Rezoning Transportation Analysis
Petition Number: Insert Zoning Petition #2021-066
General Location Identifier: 14903227

Revision Log:

Date	Description
05-27-2021	First Review (EL)
06-24-2021	Second Review (EL)
07-26-2021	Third Review (KP)

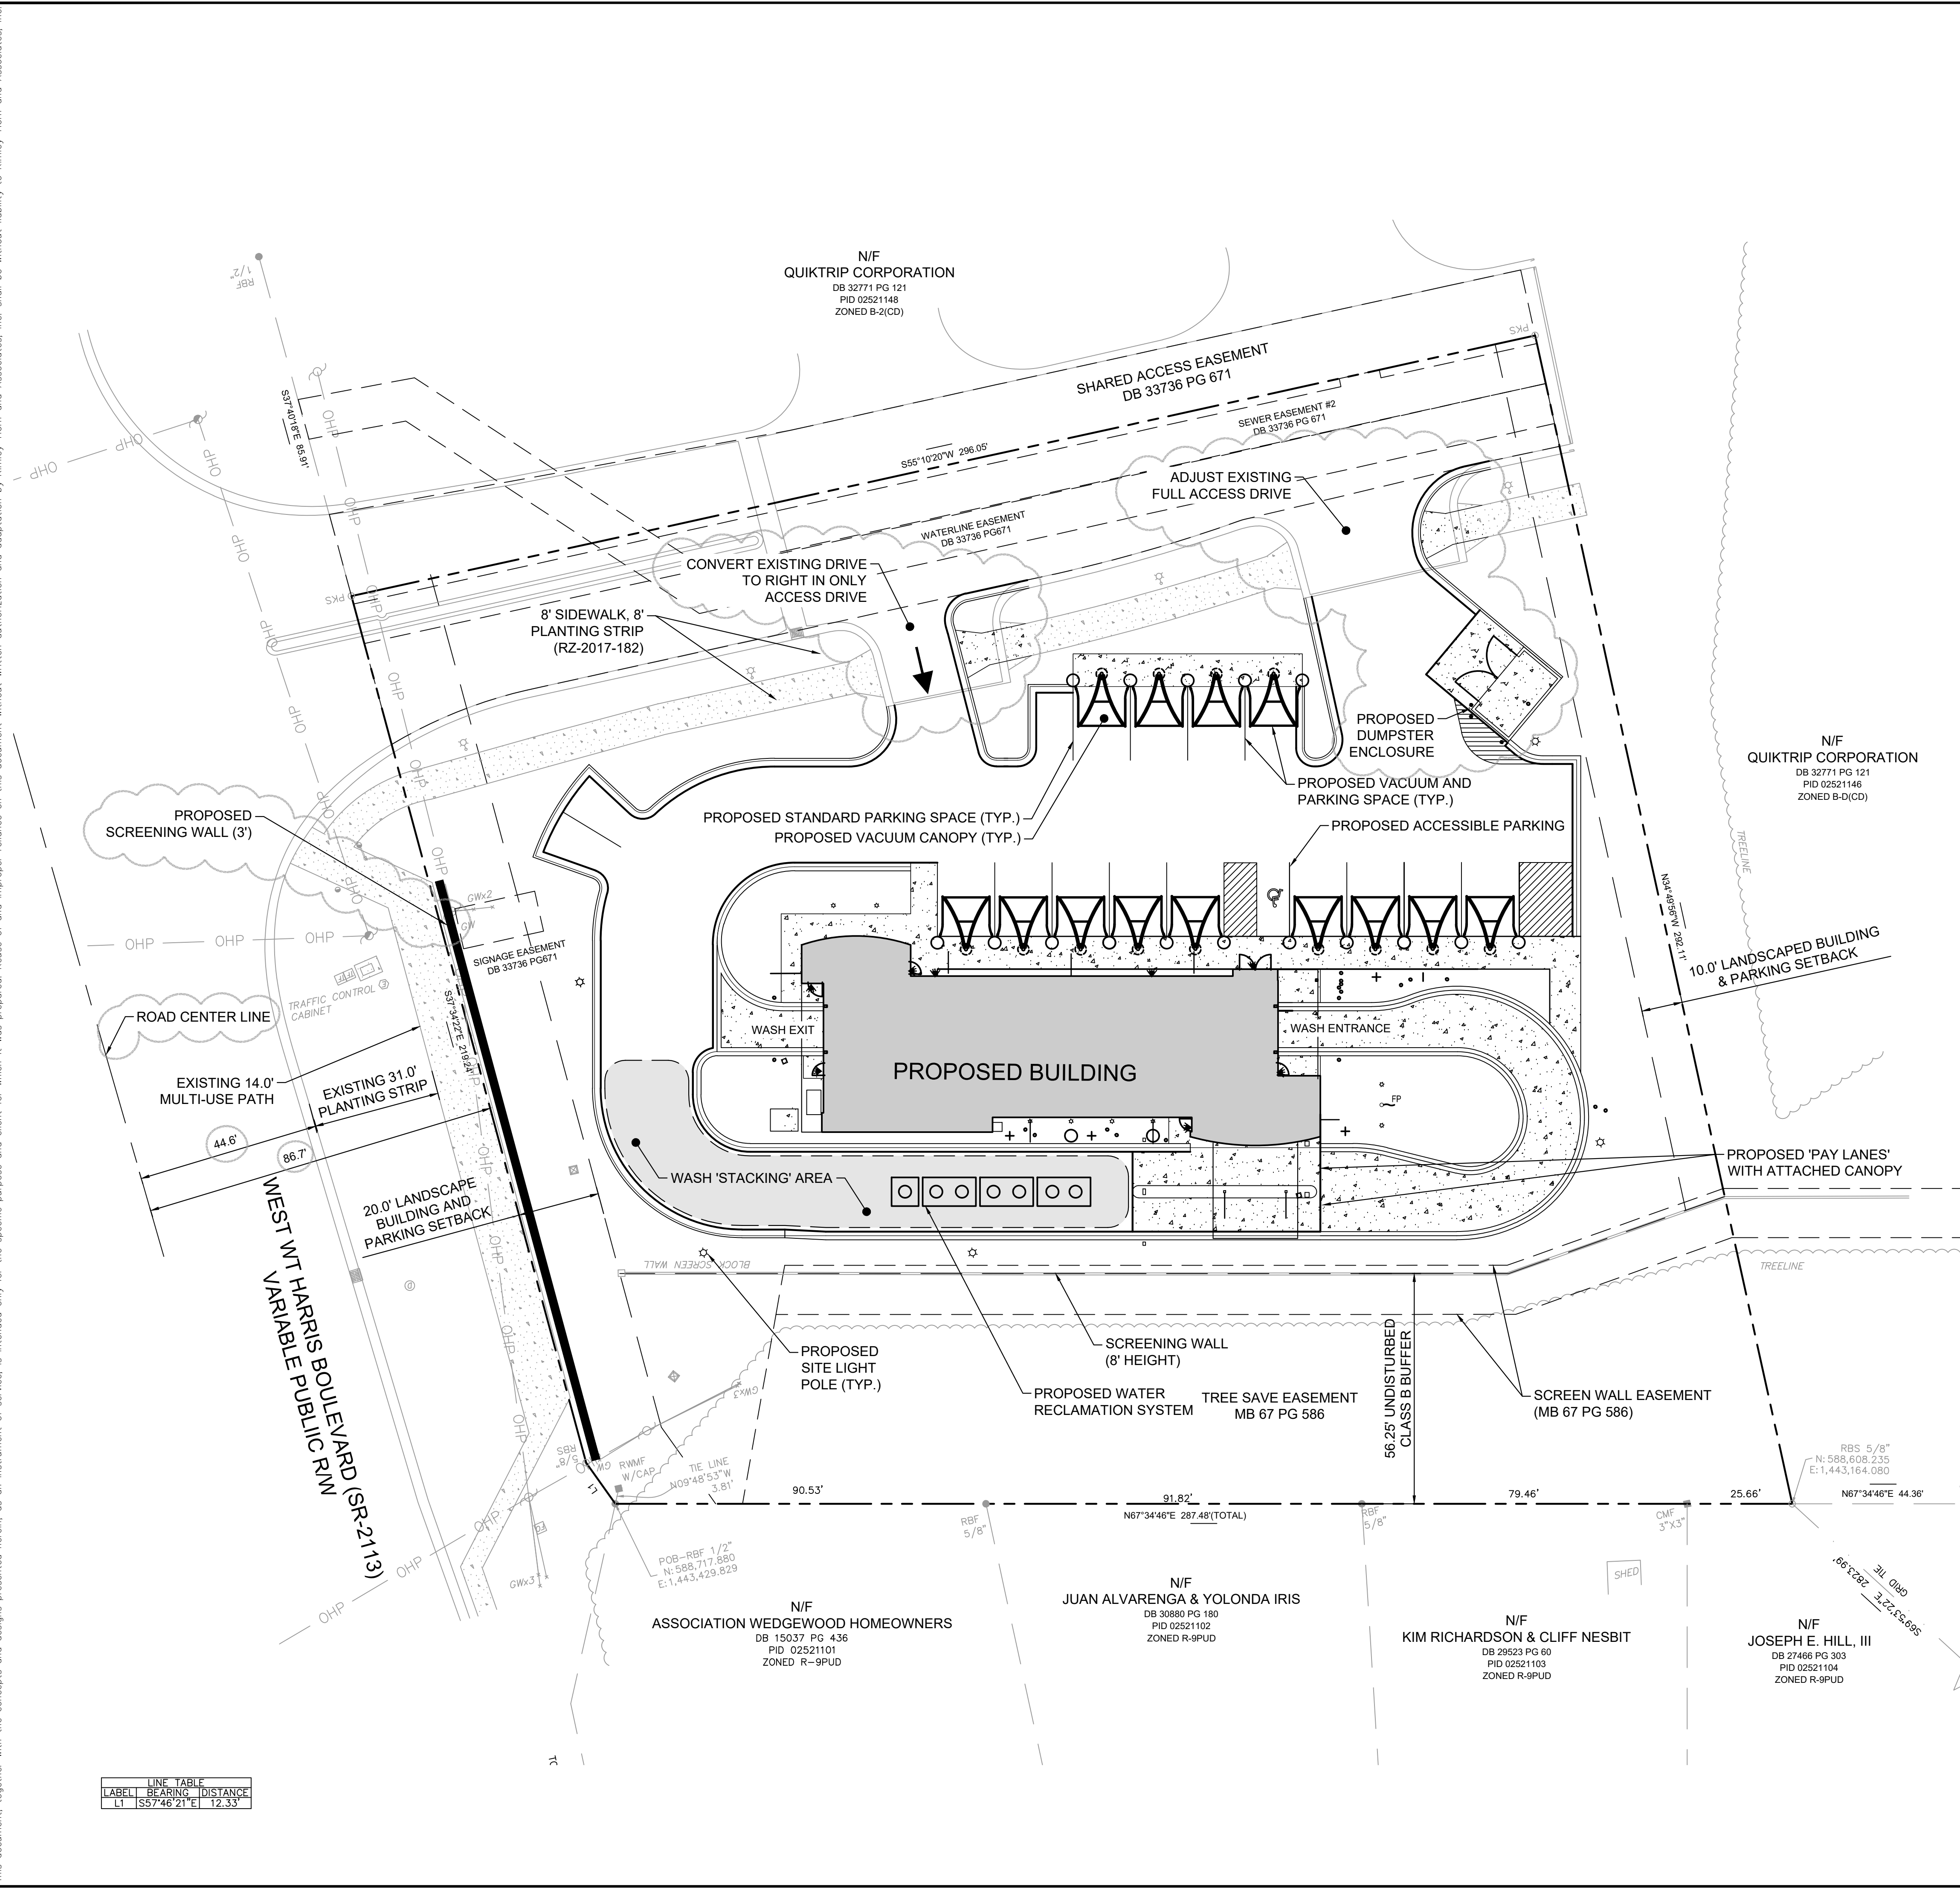
3. **Comment Rescinded** (site plan dated 6-14-21): either remove the right in only driveway and keep the full access drive, or keep the right in only access driveway and convert the full access drive to egress only. Revise the conditional note below to update this language to match the revised driveway design. Revise the site plan and conditional note (**Section 3. Access and Transportation (f)**) to modify the proposed access management per the options provided below.

5. ~~Technical Clarification (site plan dated 6-14-21): revise the site plan and conditional note(s) to incorporate the minor conditional note corrections below.~~
